REFUSAL OF PLANNING PERMISSION

APPLICATION NO. 2019/1253

Proposal Single storey rear extension to dwelling with provision balcony above and associated glass balustrades (Part Retrospective)

At 7 Warner Place, Pogmoor, Barnsley, S75 2EJ

Drawing Title **PROPOSED ELEVATIONS**

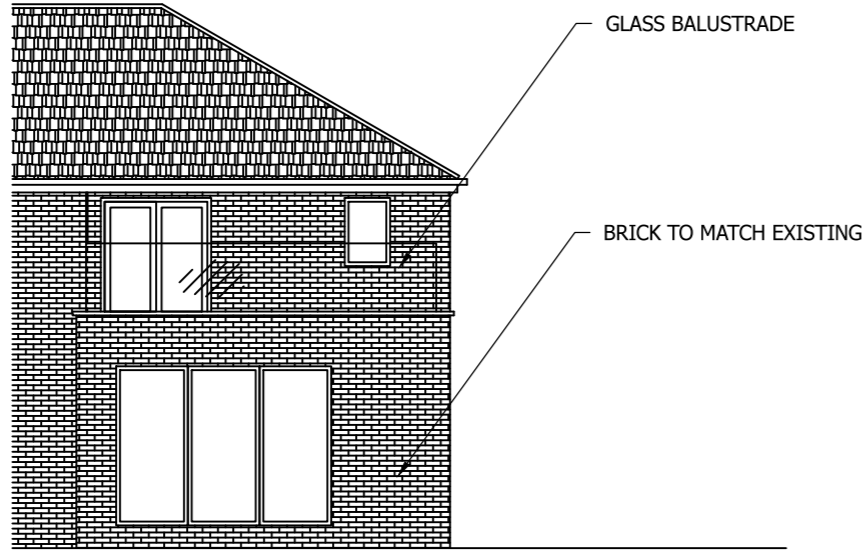
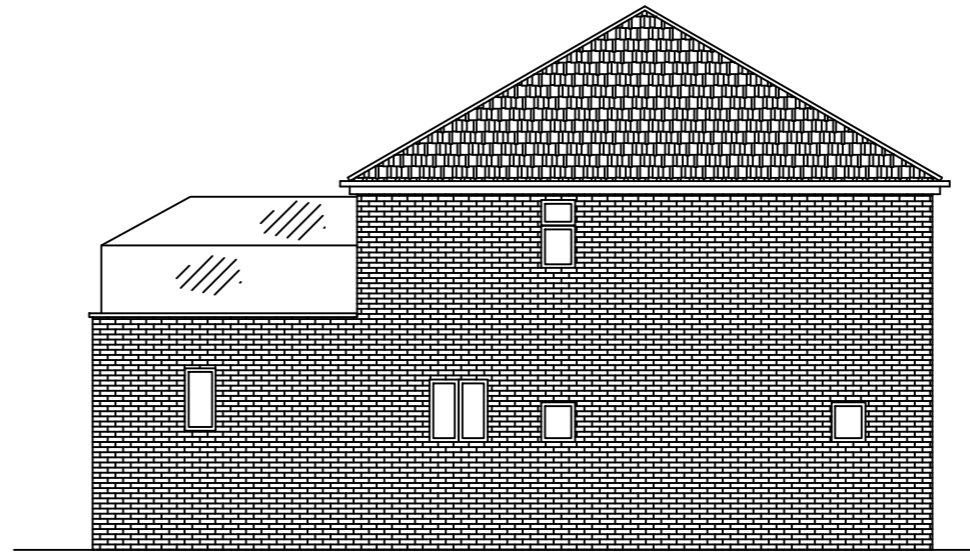
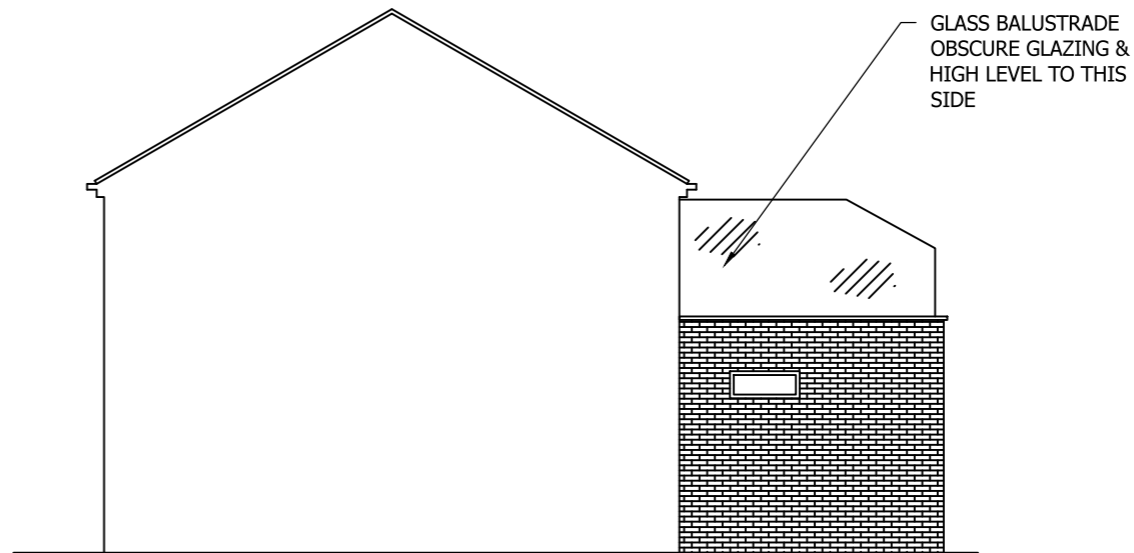
1	In the opinion of the Local Planning Authority, the proposed balcony would be materially detrimental to the amenities of the occupants of the adjacent dwellings due to significantly increased levels of overlooking, disturbance and loss of privacy, contrary to Local Plan Policy GD1, Local Plan Policy D1 and Supplementary Planning Document 'House Extensions and other Domestic Alterations'
---	---
